Rezoning Transportation Analysis

Petition Number: 2025-021

Date	Description
4-23-25	First Review (NK)
5-21-25	Second Review (NK)
7-23-25	Third Review (NK)
8-20-25	Fourth Review (NK)
9-23-25	Fifth Review (NK)

PROPOSED SITE PLAN

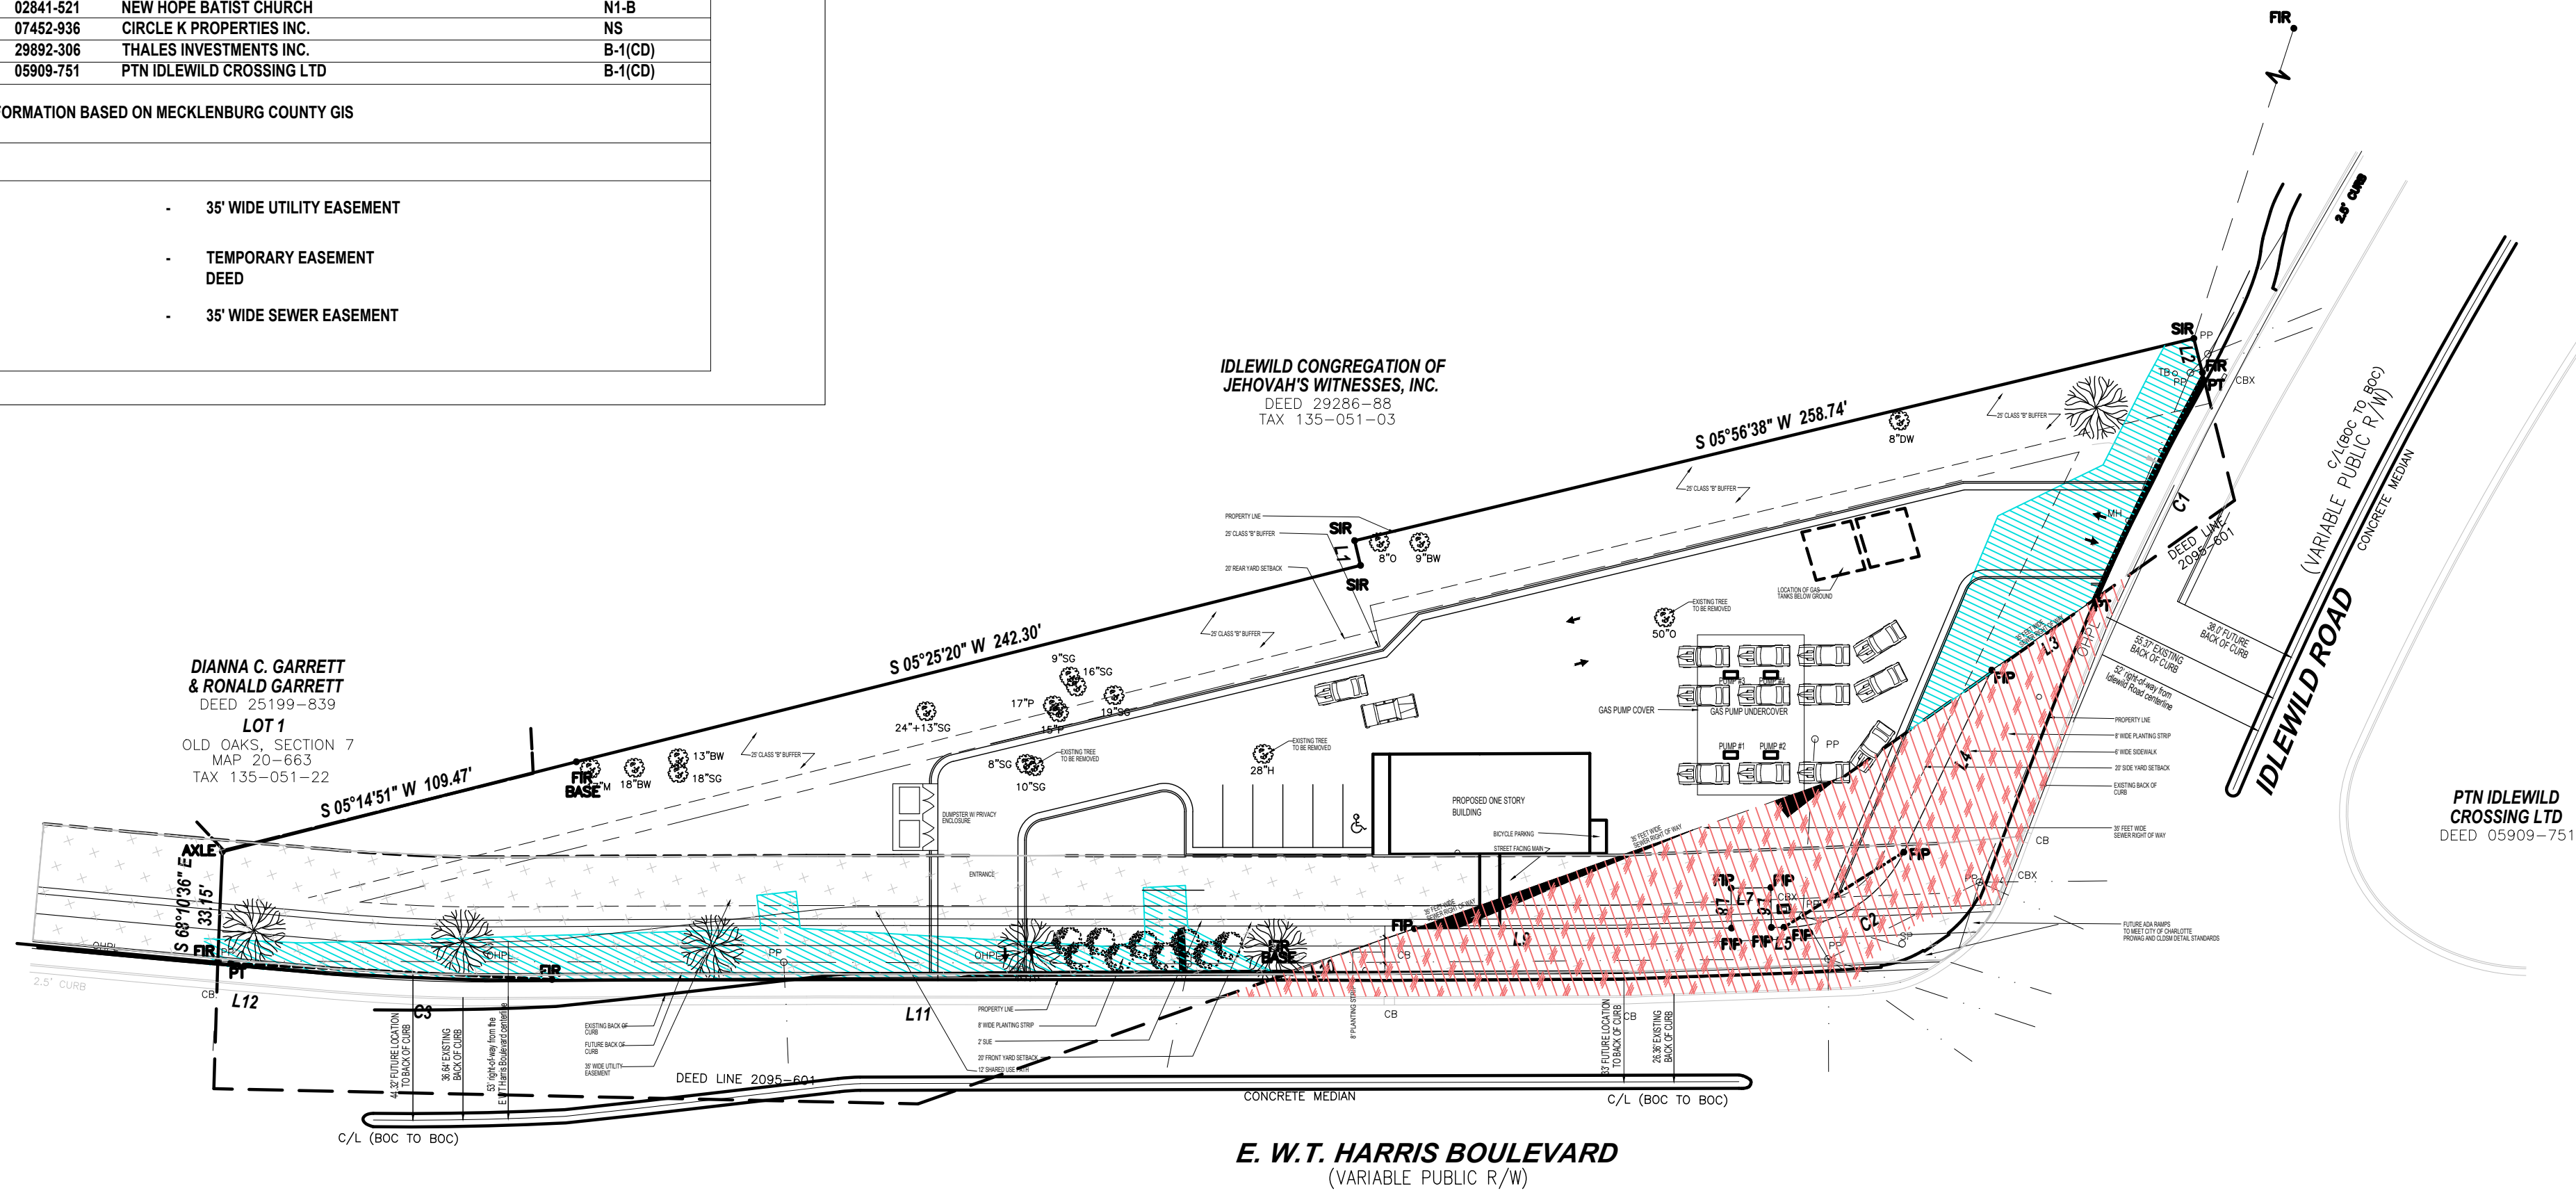
16. **Outstanding Comment from 7.22.25:** Please lighten or remove hatching so the proposed planting strip and shared-use path are clearly able to be identified.

UPDATED COMMENT 09-23-25: Remove red and blue hatching to clarify the site plan and delineate linework to identify frontage improvement.

21. **Outstanding Comment from 8.20.25:** Remove or label bold line indicated by arrow below.

Comment updated 9-23-35: Remove bold line
